From: Chantelle Bashford <Chantelle.Bashford@arun.gov.uk>
Sent: 02 February 2022 11:42
To: Planning.Responses <Planning.Responses@arun.gov.uk>
Subject: RE: Planning Consultation on: LU/411/21/PL

Application No: LU/411/21/PL
Registered: 7th January 2022
Site Address: 90-91 South Terrace Littlehampton BN17 5LJ
Grid Reference: 502860 101608
Description of Works: Change of use from existing leisure use to 10No. 1-bedroom 1 person supported living apartments, staff office, staff sleepover, and associated ancillary facilities to include extension to form new first floor, alterations to roof space including creation of dormer windows & installation of roof lights. This application is in CIL Zone 4 (zero rated) as flats.

project	Proposed Development 90-91 South Terrace Littlehampton, W Sussex		
drawing	1st & 2nd Floor Fire Strategy Plan		
drawn	MAS	checked	
date	Dec 2021	status	Planning
at scale	a3 scale	rev	28118-PD121
1:100	1:200

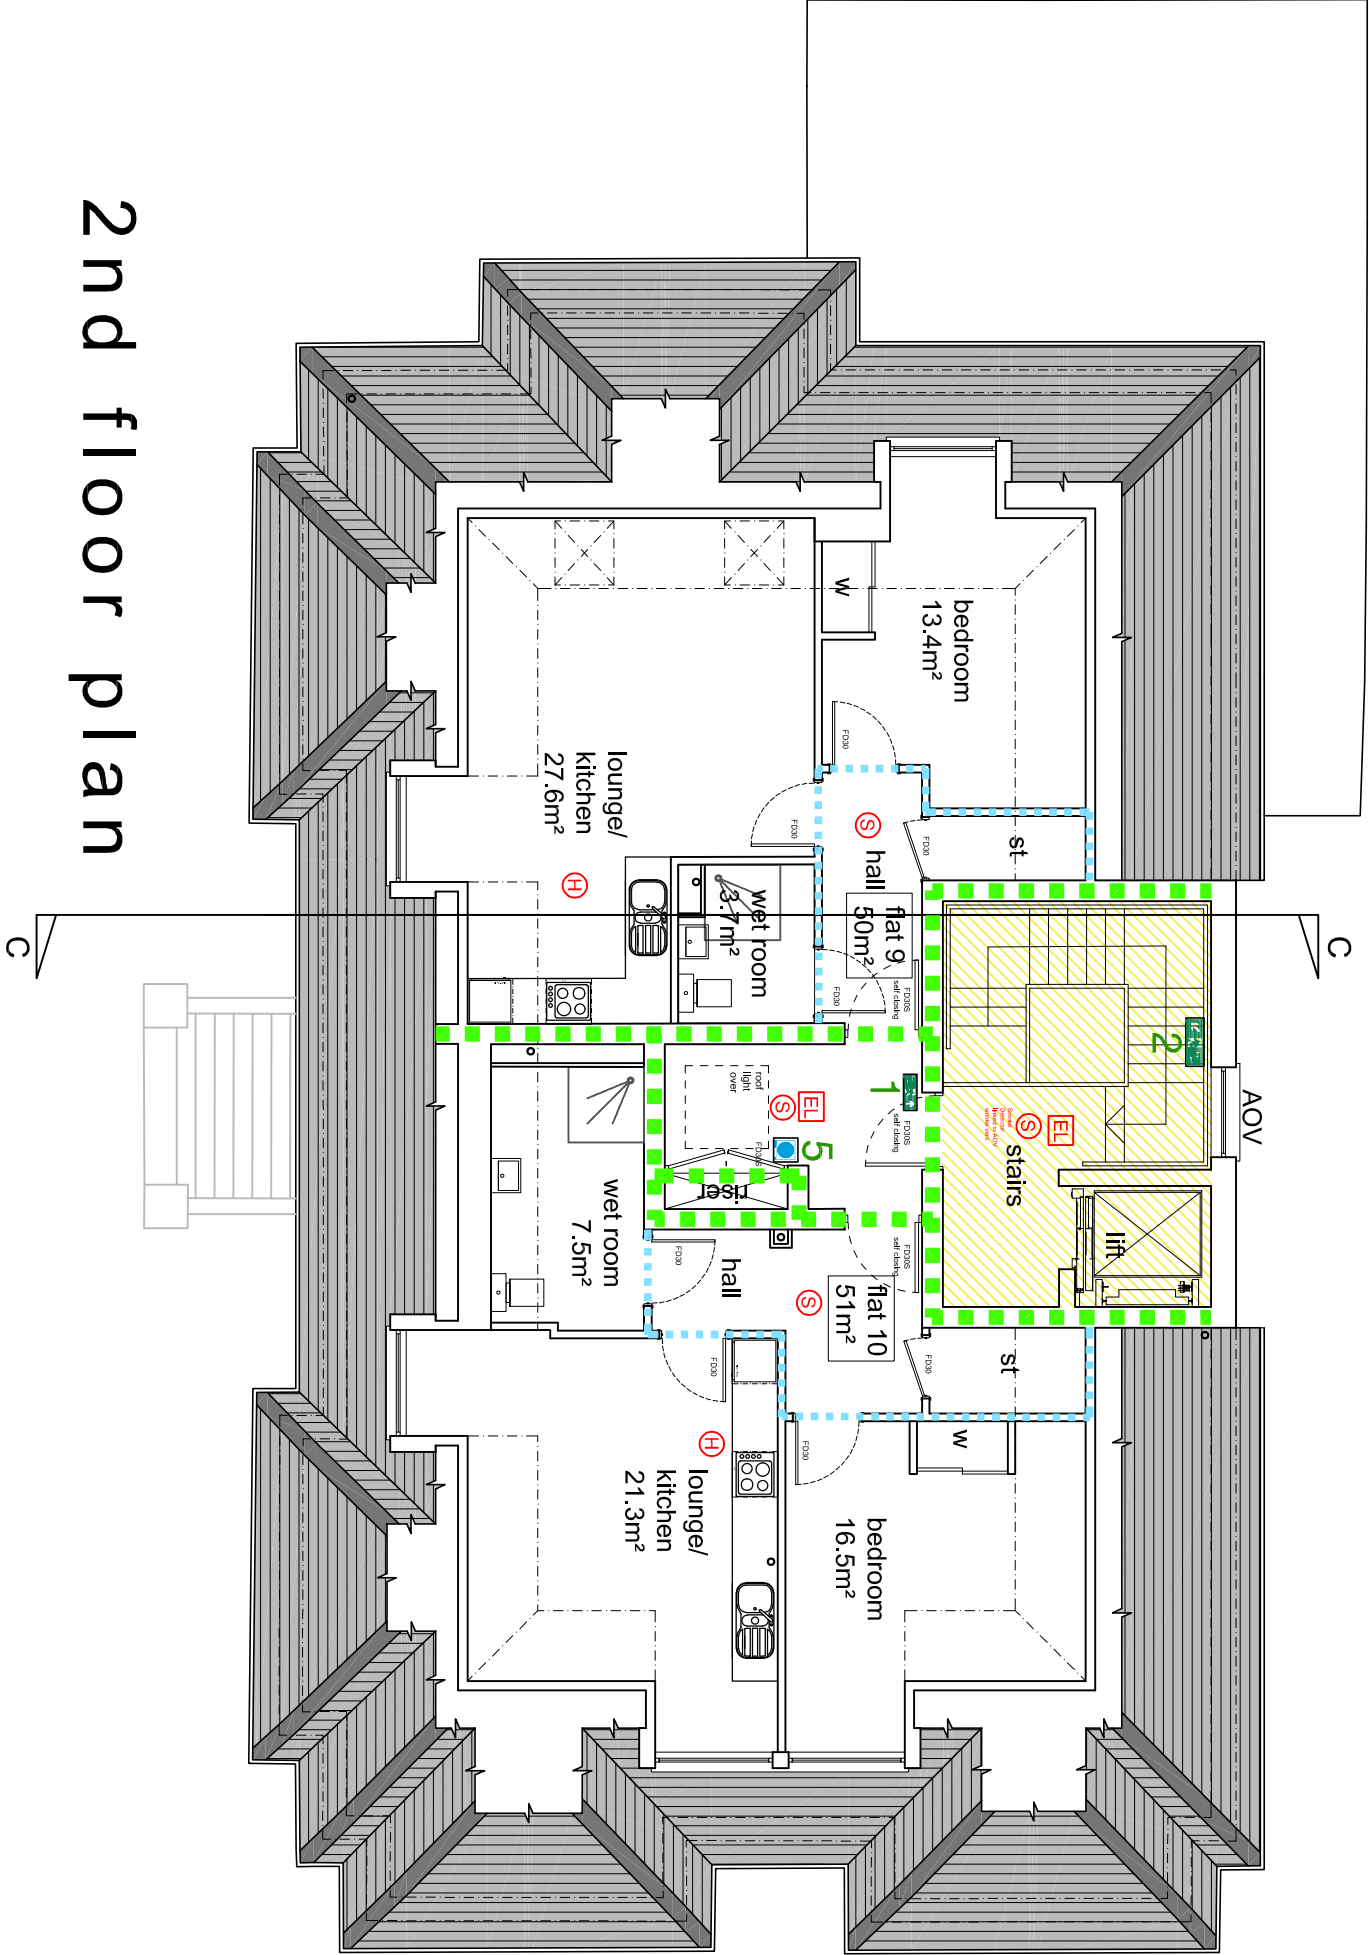
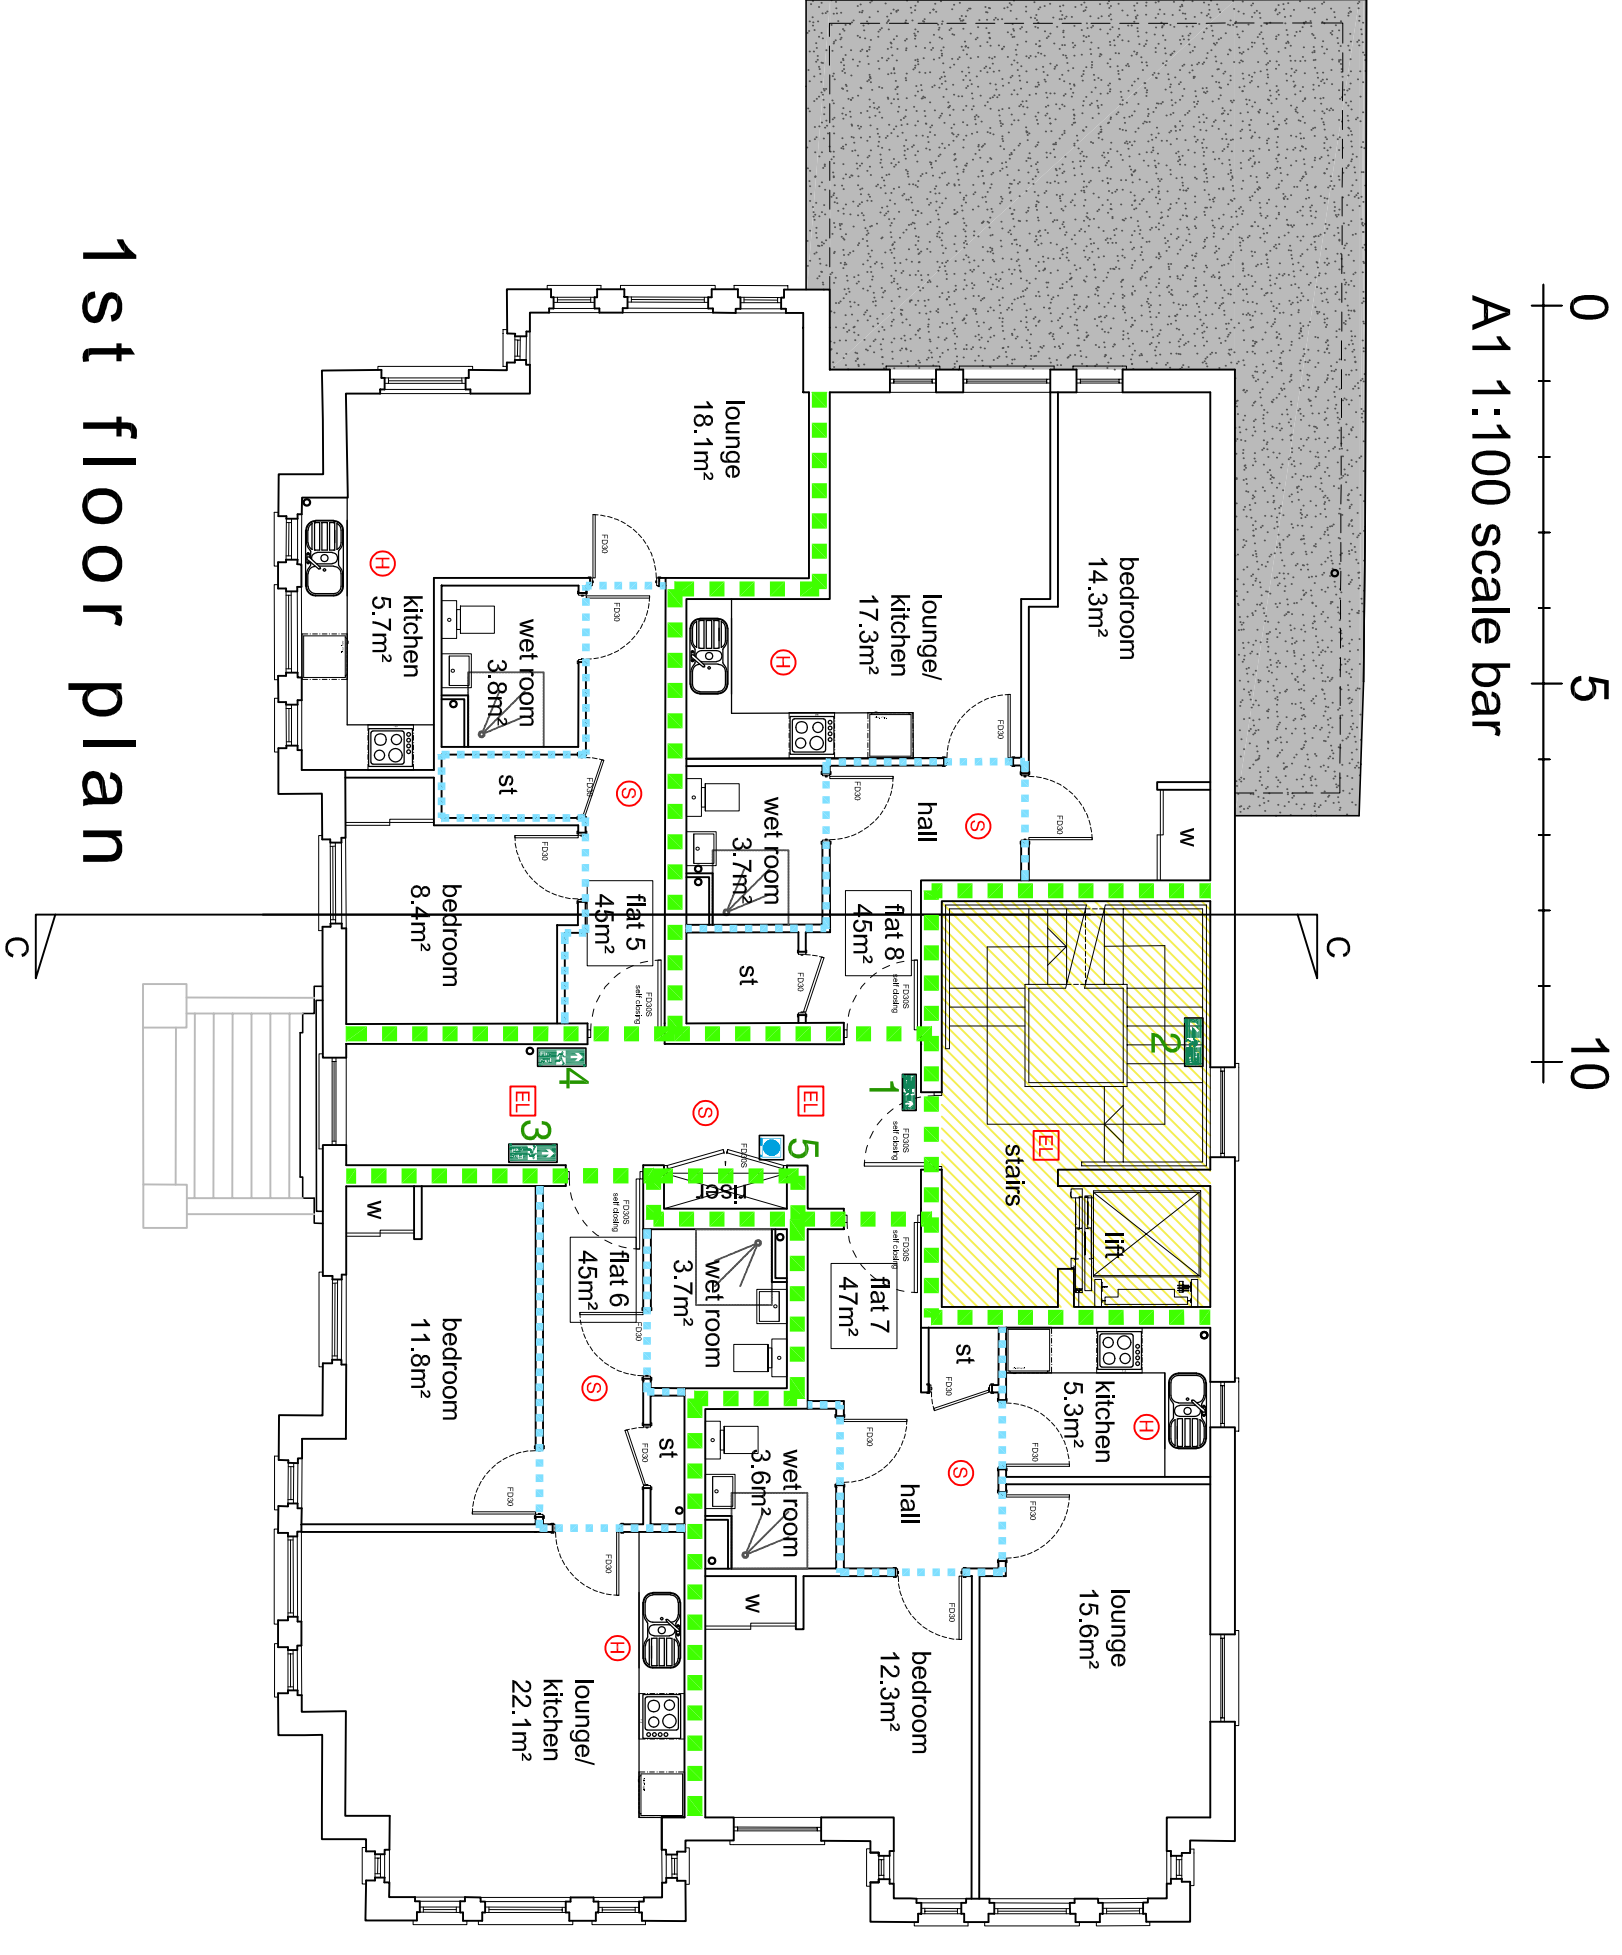
- Flats 9 & 10 appear to have sloped ceilings to the rooms. A note regarding sloped ceilings: the floor to ceiling height must be a minimum of 2.1 metres over at least 50% of the floor area when measured on a plane of 1.5 metres from the floor
